From: Laura Gibbons <Laura.Gibbons@arun.gov.uk>
Sent: 12 October 2021 15:49
To: Planning.Responses <Planning.Responses@arun.gov.uk>
Cc: Michael Eastham <Michael.Eastham@arun.gov.uk>
Subject: RE: Planning Consultation on: CM/48/21/RES

Engineers Comments Regarding Surface Water Drainage

Application No: CM/48/21/RES

Site Address: Land to the West of Church Lane South of Horsemere Green Lane Climping

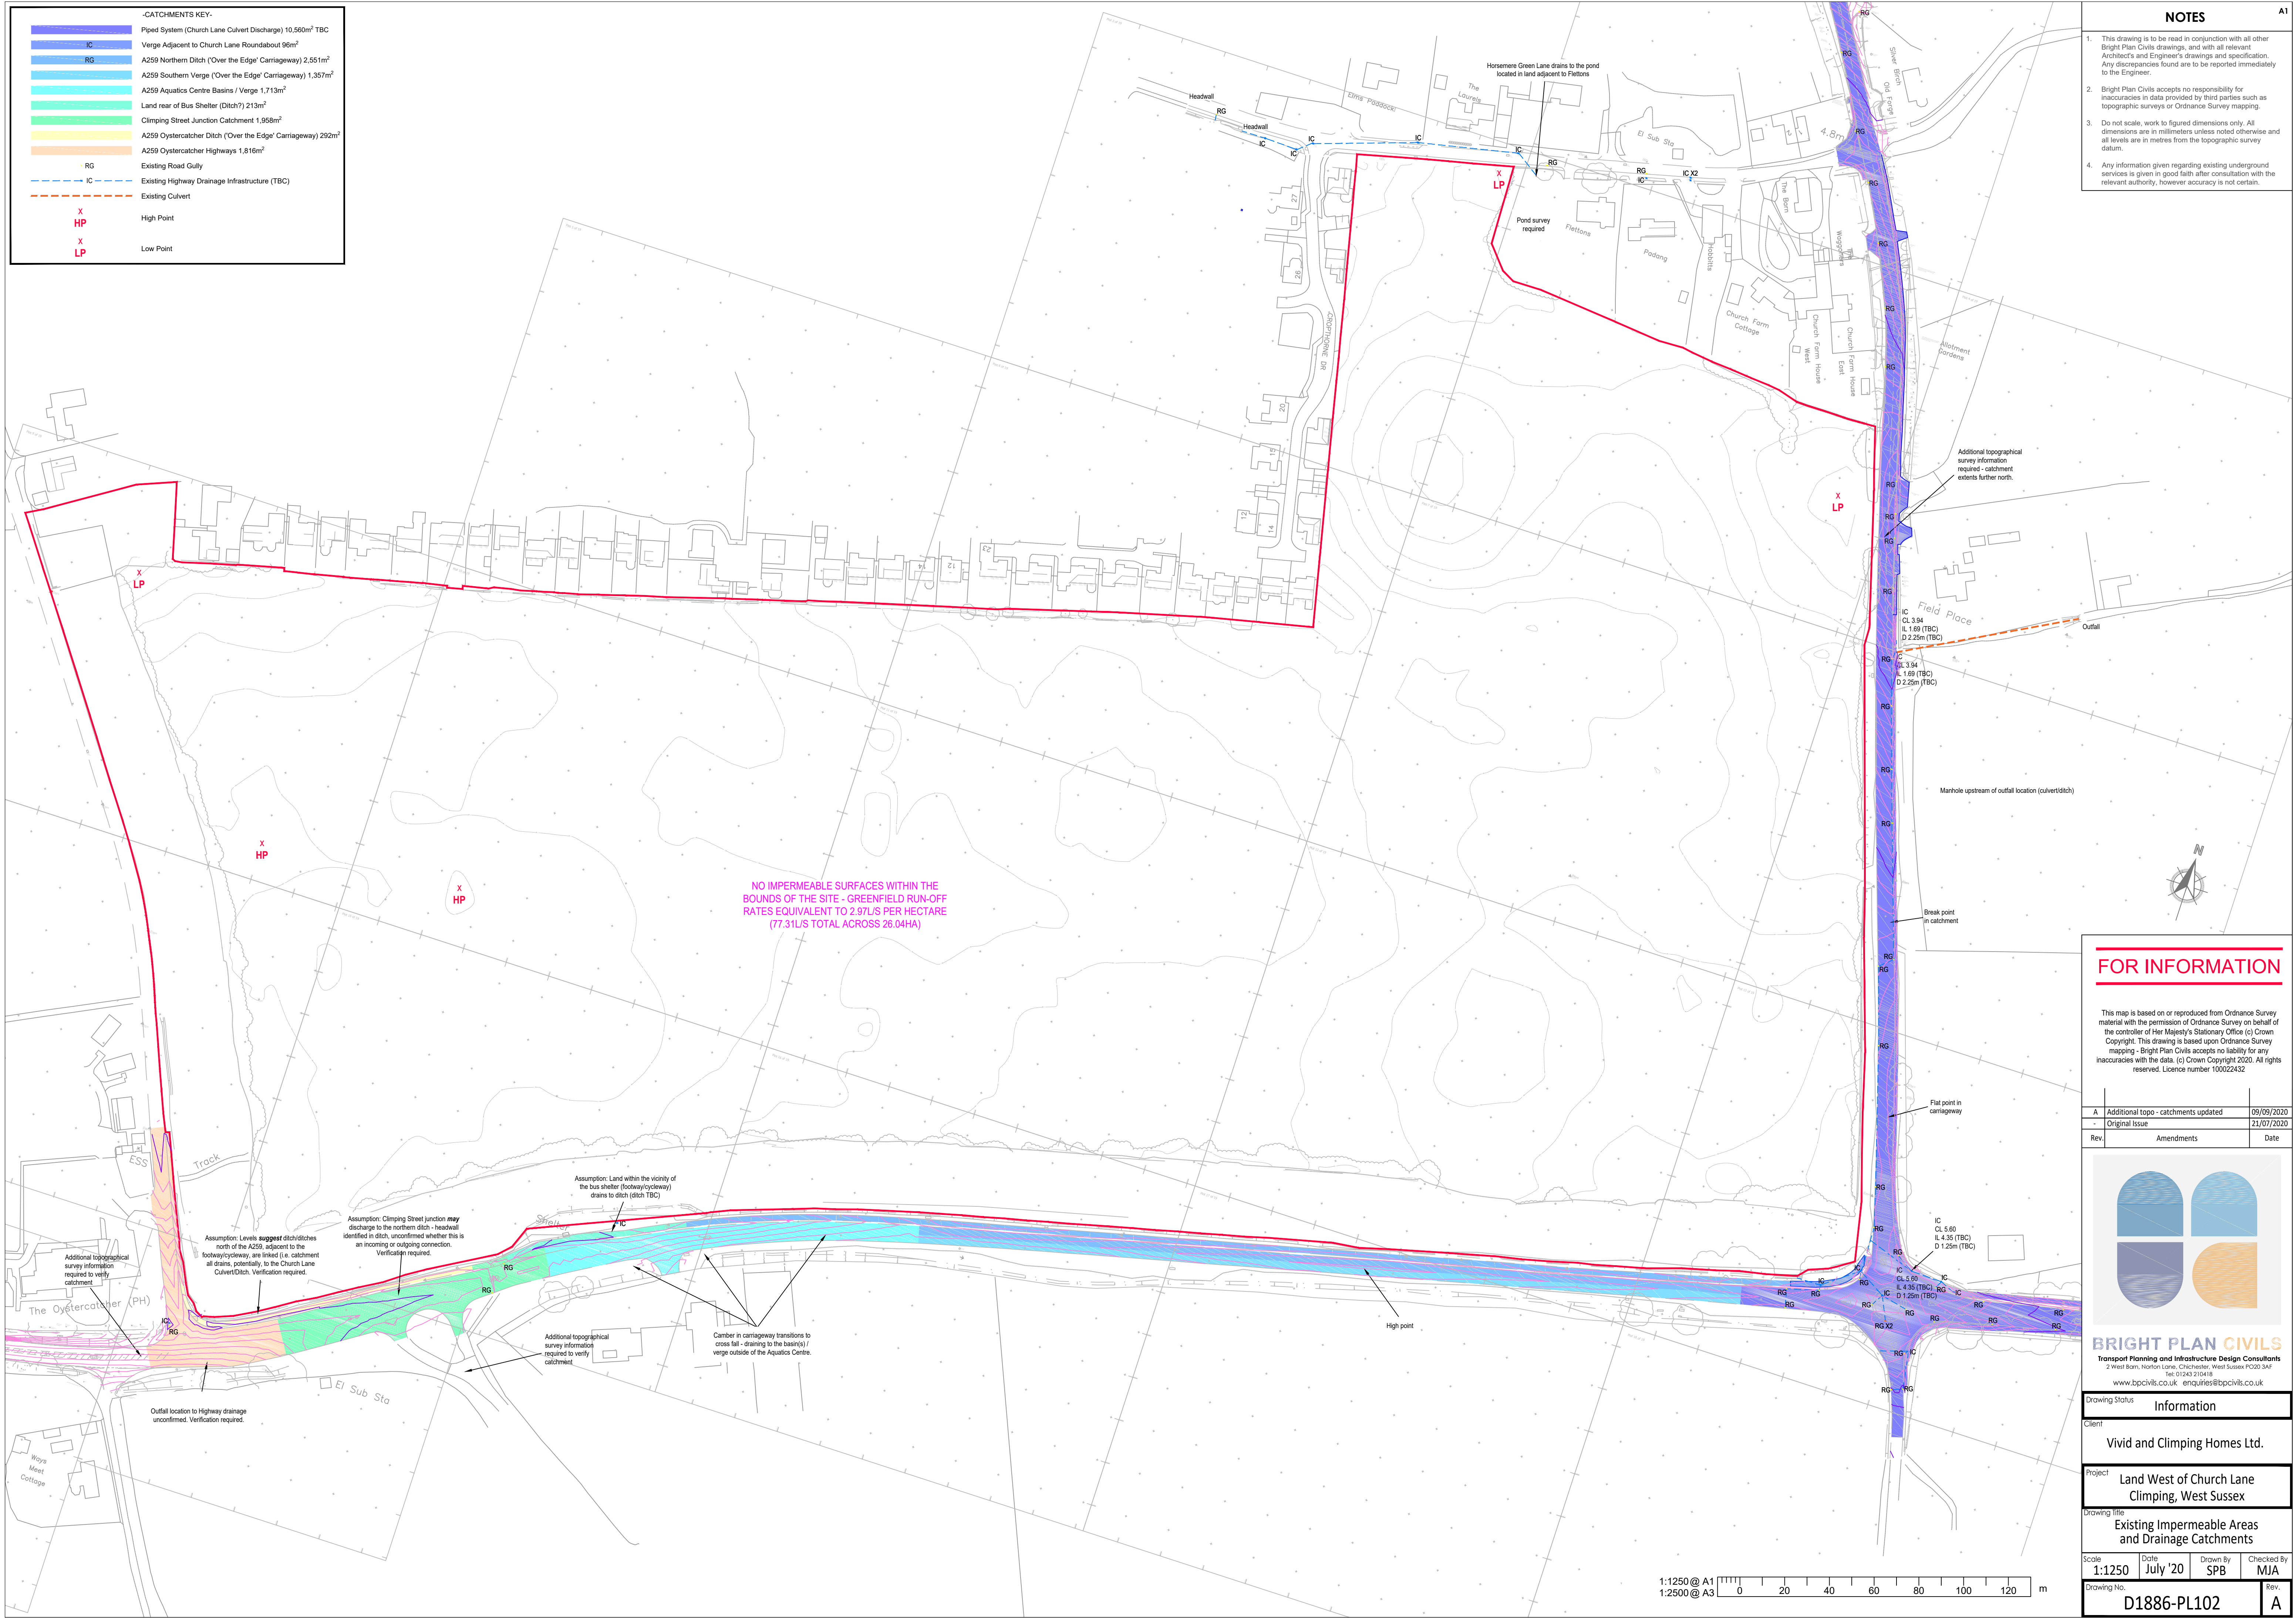
It is apparent that the downstream network requires some work. It is unclear whether the network has adequate capacity to receive the proposed flows. The proposed drainage strategy is for all discharge to be directed to one

location, it is not believed that this reflects the natural catchments. Evidence of existing catchments of the field should be submitted.

- Indicative cross sections of proposed basins (two perpendicular sections per basin) showing the size of basins, slopes, maximum water levels, and surrounding ground levels.
- Catchment delineation for the undeveloped field, to show what area drains to the east currently.
- An assessment of greenfield runoff for the catchment which would drain to the proposed point of discharge.
- Preliminary floatation calculations and depths of material required to resist floatation at basins.
- Evidence that the receiving network has capacity to receive additional flows.
- A buffer plan showing 3m clear maintenance buffer around all proposed basins and watercourses/ swales.
- A plan showing that basins are clear of root potential areas.

Drawing Status	PLANNING		
Client	Vivid and Climping Homes		
Project	Land adjacent to Church Lane, Climping, West Sussex		
Drawing Title	Proposed Drainage Sheet 2 of 4		
Scale	1:500	Date	Aug '21
		Drawn By	SPB
		Checked By	MJA
Drawing No.	D1886-002		
		Rev.	B

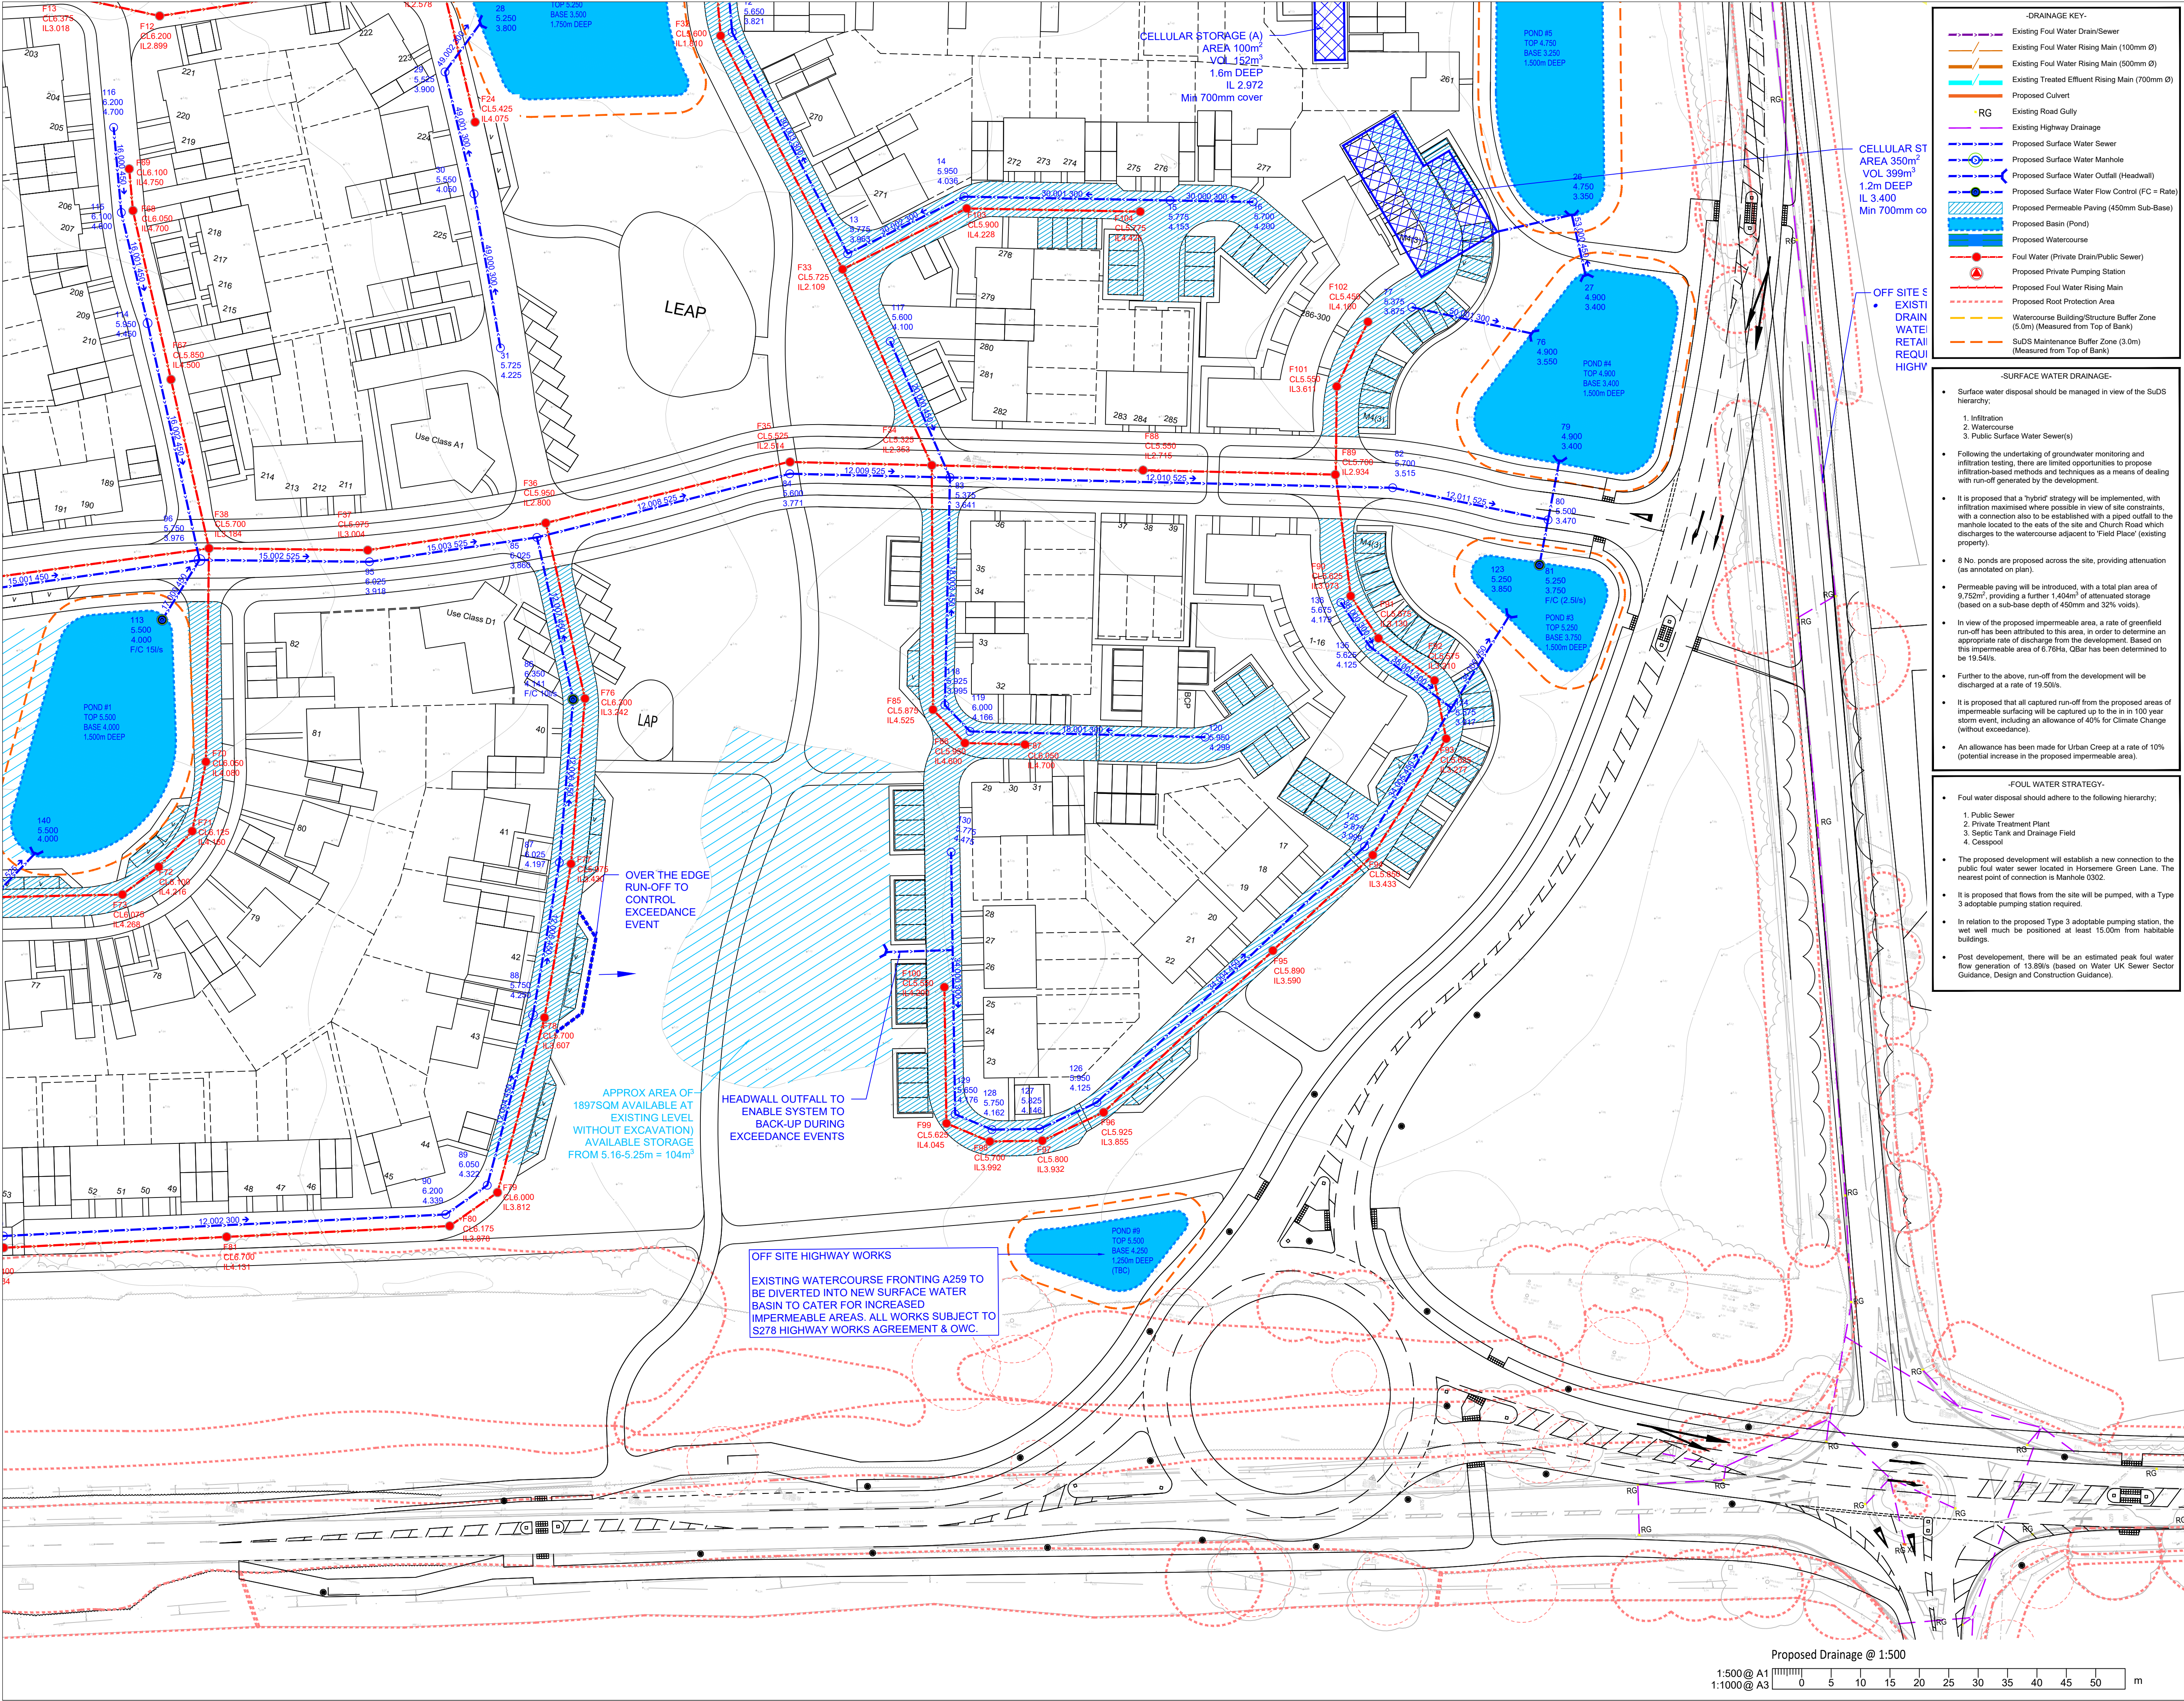
The surface water drainage strategy looks to utilise attenuation. The proposals include some winter groundwater monitoring, we wish to highlight that the monitoring has not been completed over a full winter period. Further winter groundwater monitoring October to March inclusive will be required to support detailed design. The groundwater monitoring locations should be targeted to reflect the proposed drainage strategy. Even if attenuation is accepted winter groundwater monitoring at the location of proposed basins and accompanying floatation calculations will be required.

It appears that basins are proposed in close proximity to site boundaries, and that proposed trees are very close to basins. Root potential areas of trees should not overlap with basins.
